Consultation Response from KC Highways		
2019/90402 Schenro, 3, Shelley Woodhouse Lane, Shelley, Huddersfield, HD8 8NB		
Erection of detached dwelling, demolition of existing dwelling and associated works		
Date Responded:26/3/19	Responding Officer:CNB	Responding Ref:K17-5/3
This application is for the demolition of an existing detached dwelling and the replacement with a detached dwelling with an existing access on to Shelley Woodhouse Lane. In the vicinity of the site Shelley Woodhouse Lane is a two way single carriageway rural distributor road of approximately 5.5m width set at the National Speed Limit. There are no footways but street lighting is present. There were no trip generation details supplied with the application, however as there is an existing detached dwelling that is to be demolished, it is expected that there will be minimal increase in trips from the site. It is doubtful that the access can achieve the recommended visibility splays for a 60mph road which would be just over 200m based on DMRB figures, however the access is existing, there is no intensification of use and there are no accident records that are connected with the access on Shelly Woodhouse Lane (the

CLIENT MR & MRS M FAIRBROTHER			DRAWING TITLE SITE PLAN - PROPOSED			
PROJECT 3 SHELLEY WOODHOUSE LANE, SHELLEY			JOB NO 3878	DRG NO 04	REV A	SCALE @ A3 1:200
						DATE 13 05 16

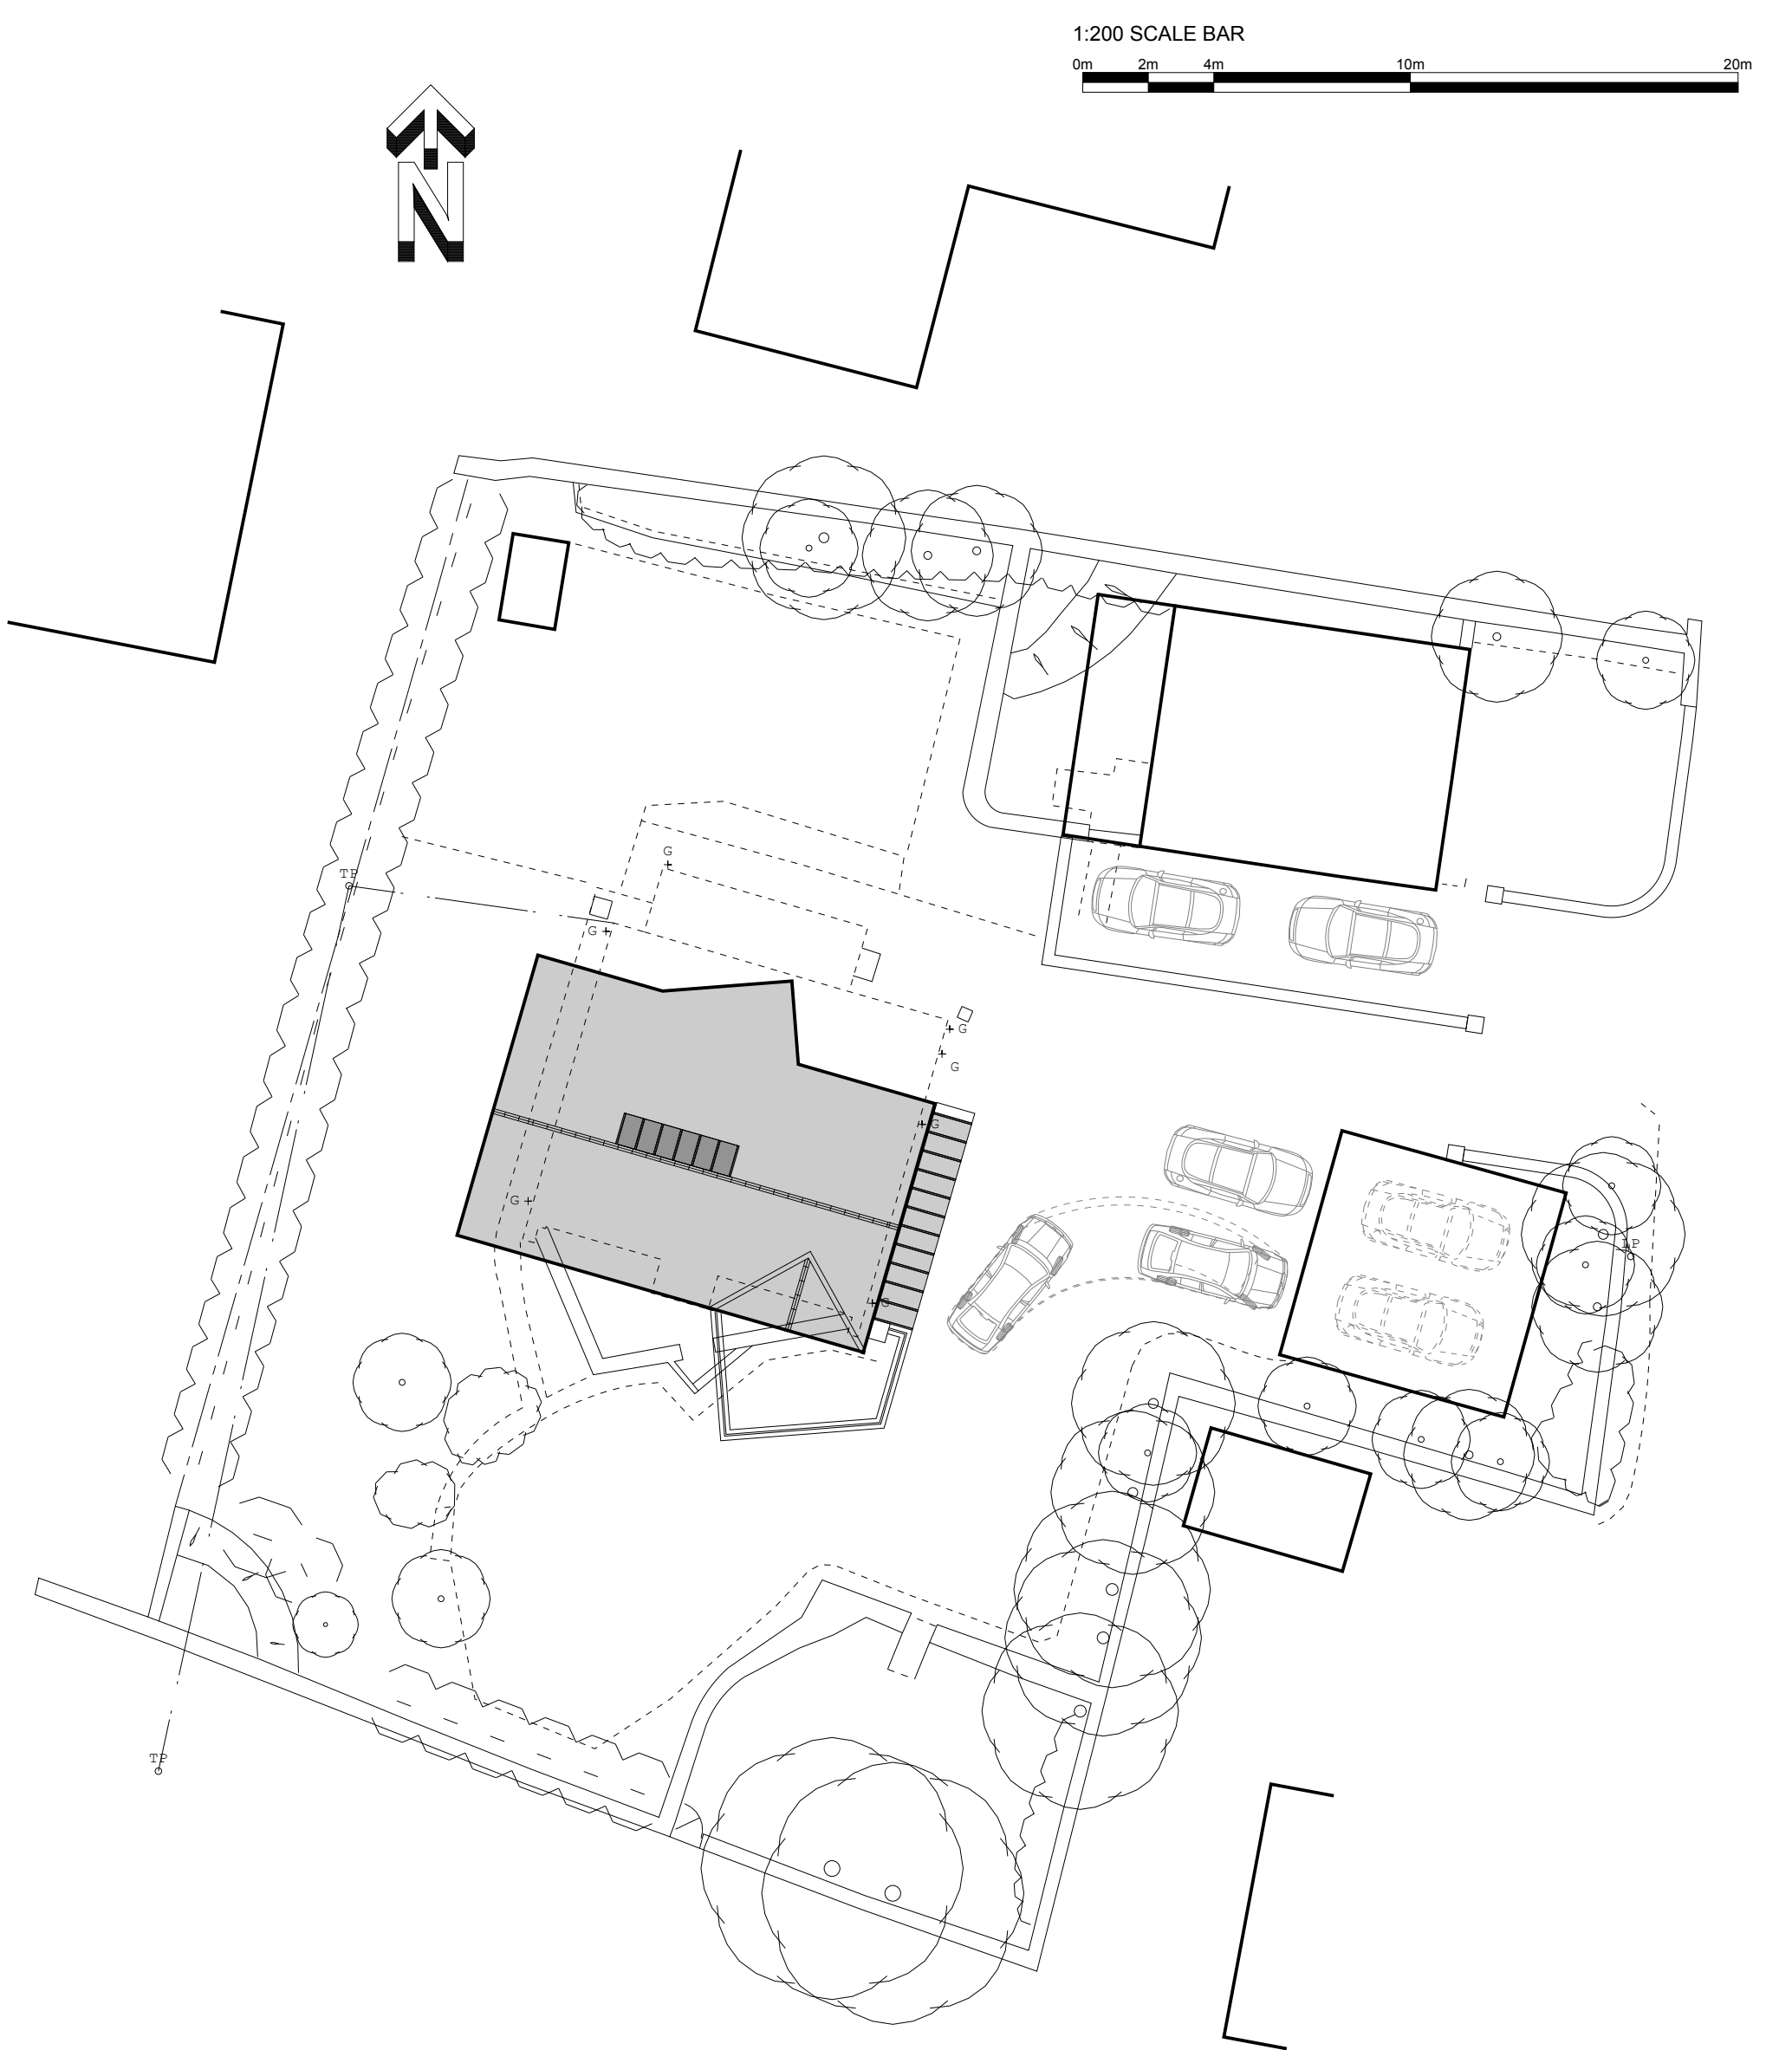
The approved vehicle parking areas need be surfaced and drained in accordance with the Communities and Local Government; and Environment Agencies 'Guidance on the permeable surfacing of front gardens (**parking areas**)' published 13th May 2009 (ISBN 9781409804864) as amended or superseded.
